AW/159/13

ARBORICULTURIST'S COMMENTS

From: Ian Brewster
Sent: 22 August 2013 13:02
To: Janice Chapman
Subject: RE: AW/159/13 - New garage to front of site at 78 Barrack Lane, Aldwick

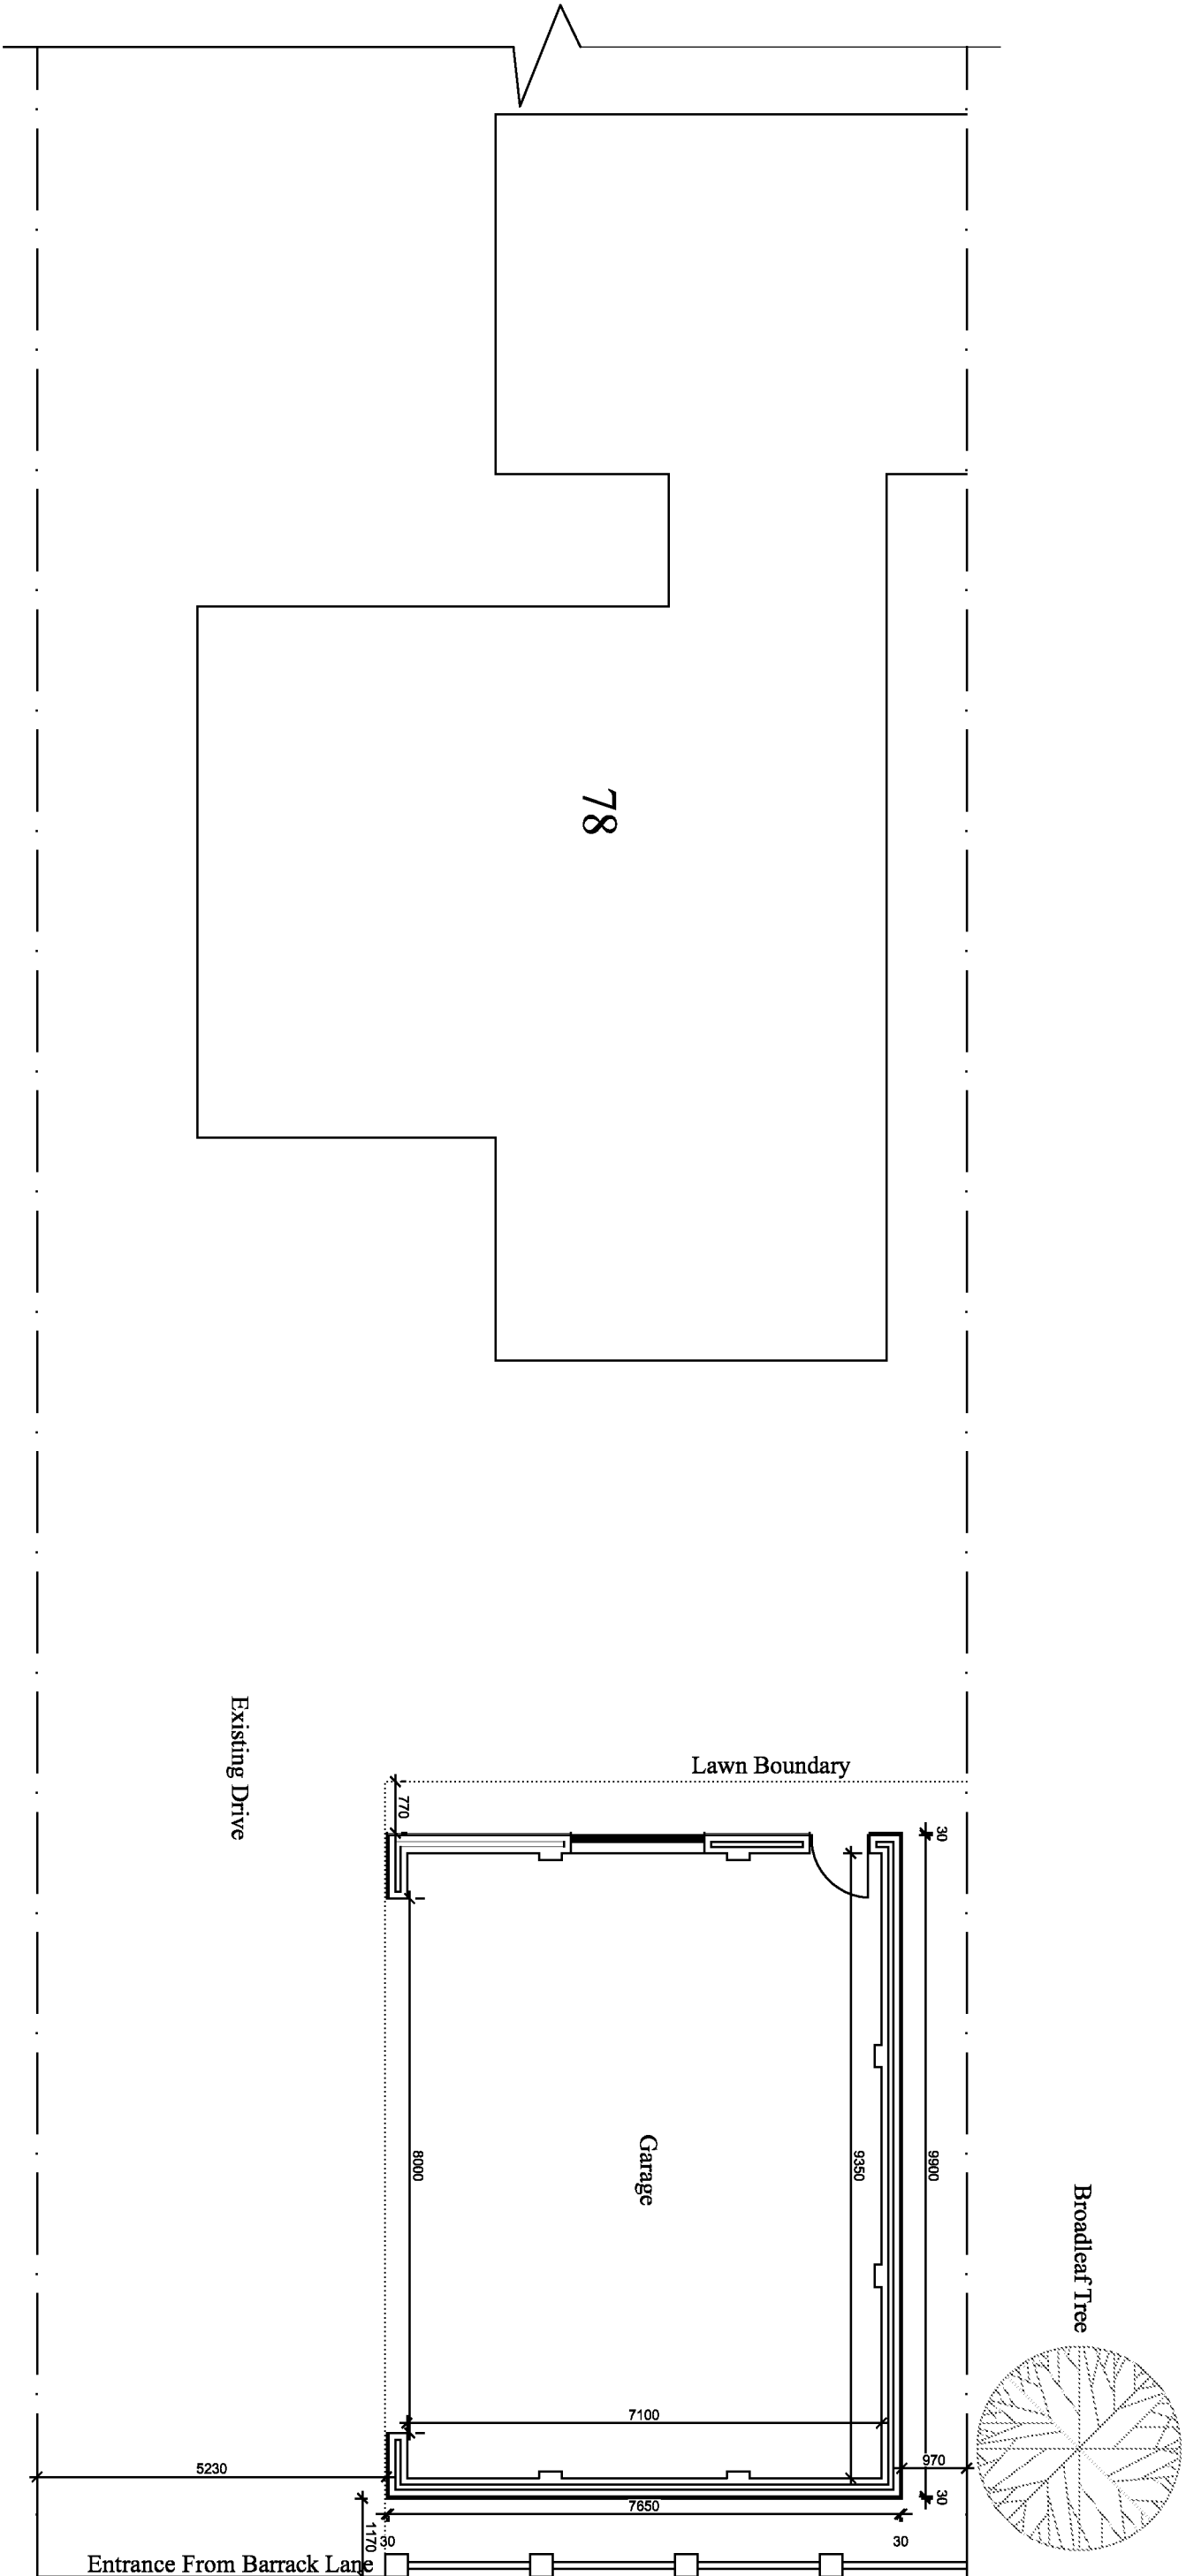
Thank you for your message. I have identified the tree as a mature Hornbeam of particular visible significance as providing good visual amenity and hence its worthiness as a TPO tree. The garage surface area would affect a large percentage of the trees roots. Even if the garage was suspended it would adversely affect water percolation and altering the rooting environment/soil ecology which would be detrimental to this mature specimen. I therefore object to the proposal on the grounds that the development would directly damage a significant proportion of the live underlying roots and also disfiguring facilitative pruning of branches to allow the structure to be built.
